RE: Drainage Conformance Letter
Dutch Bros. Coffee – Falcon Marketplace – Lot 11
7510 Falcon Market Place, Falcon, Colorado 80831
Our Job No.

Drainage Conformance Letter

DUTCH BROS. COFFEE - CO0707 - PEYTON, CO PROPOSED CONDITIONS MAP

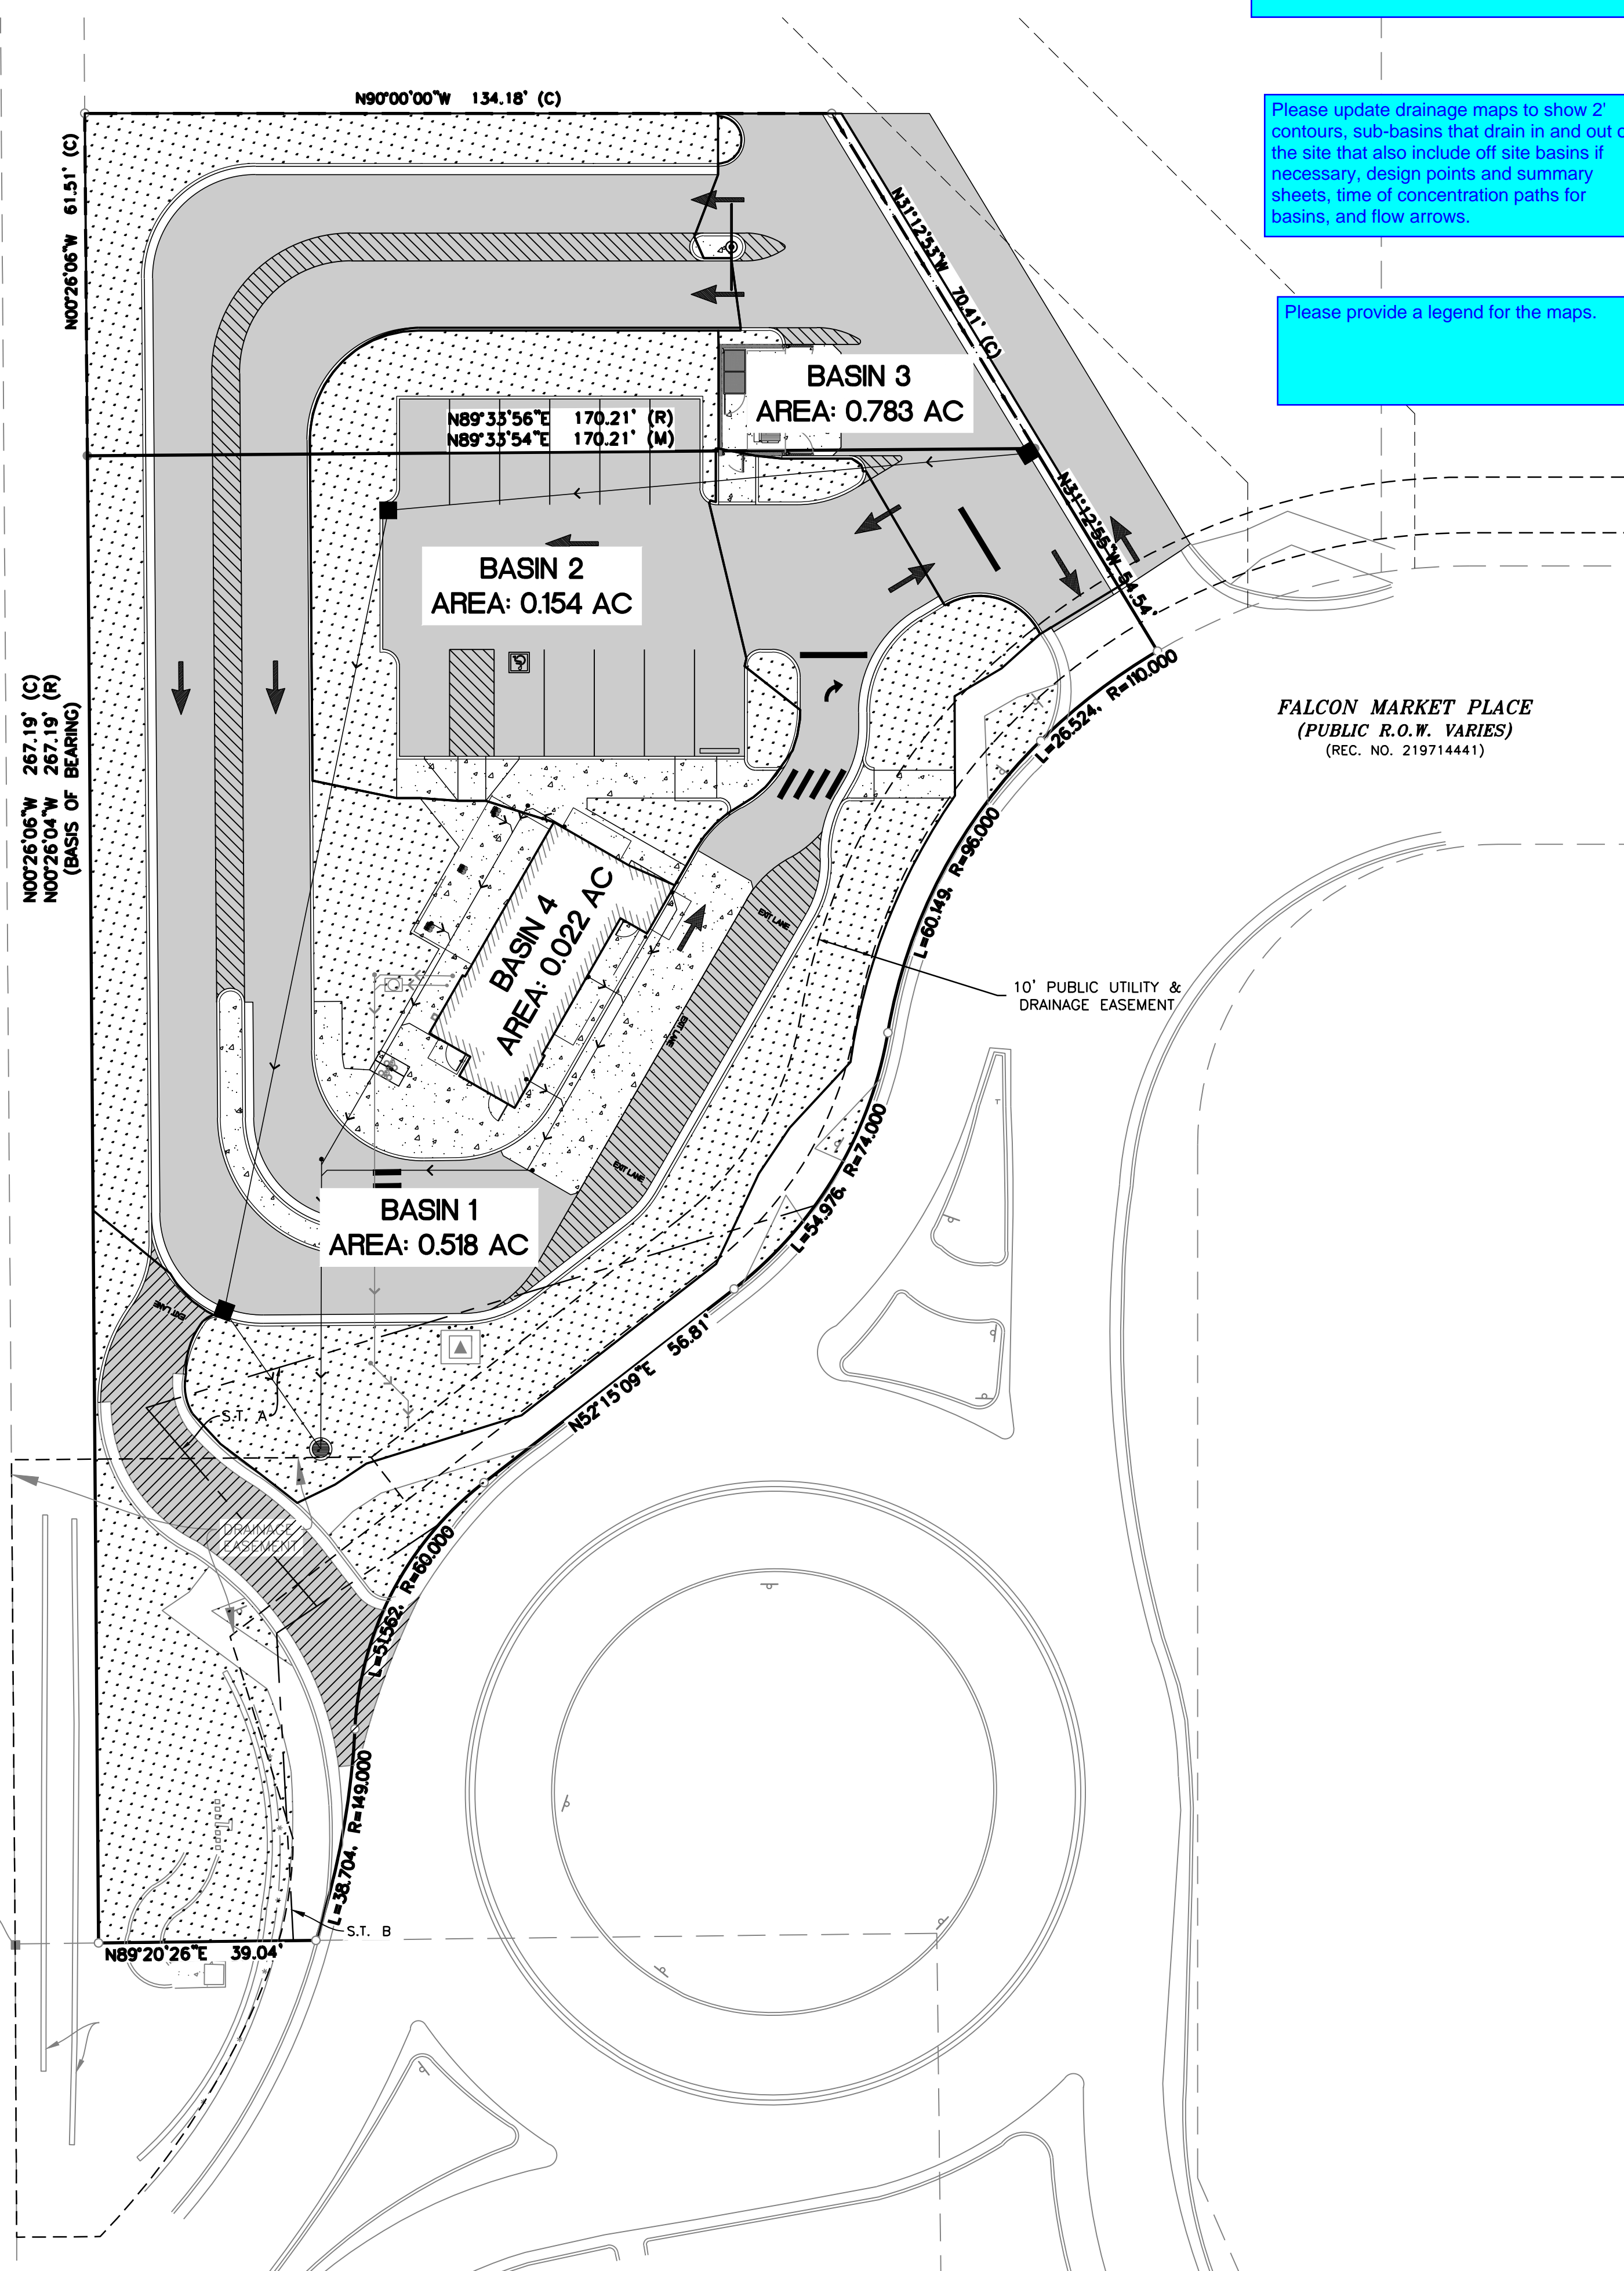
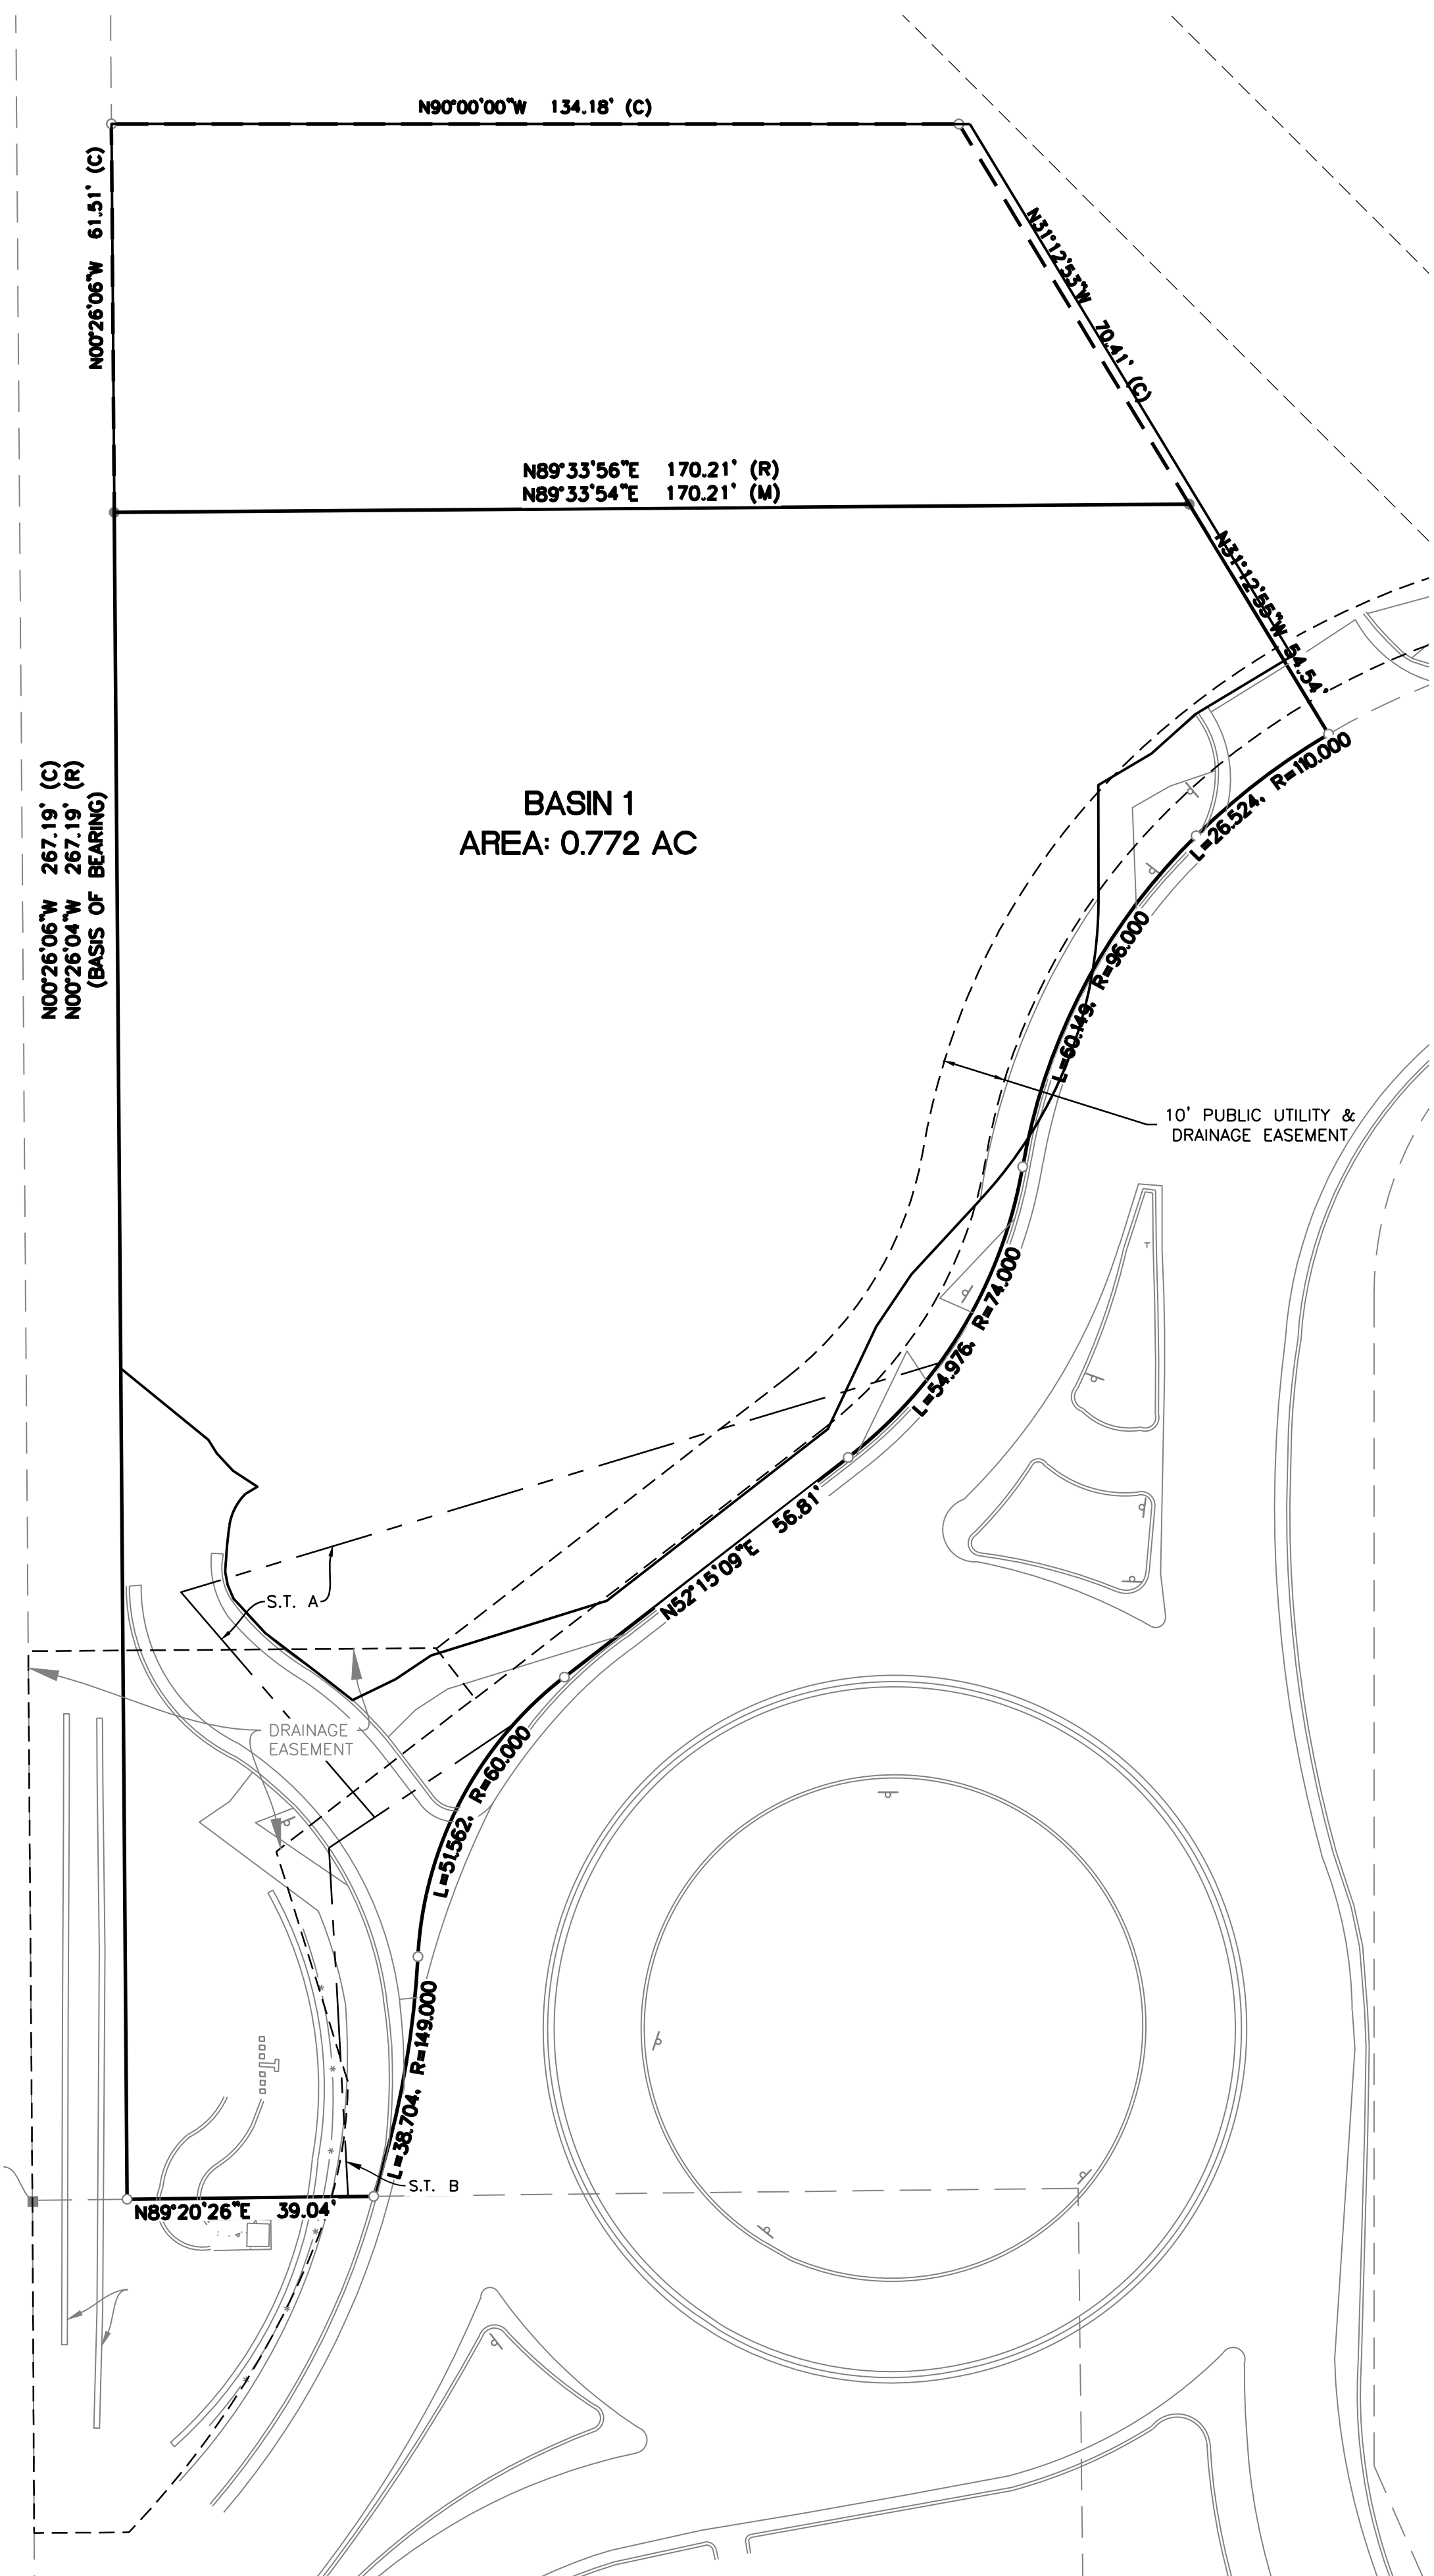
Please reference DCM Vol.1 section 4.5 for drainage letter content requirements. The purpose of the drainage letter is to provide site specific information, calculations, and drainage maps to show conformance with previous drainage report for Falcon Marketplace. If you have any questions please feel free to contact Lupe Packman at 719-313-6215. Please note drainage letter should also include signature blocks. See attachment next to comment.
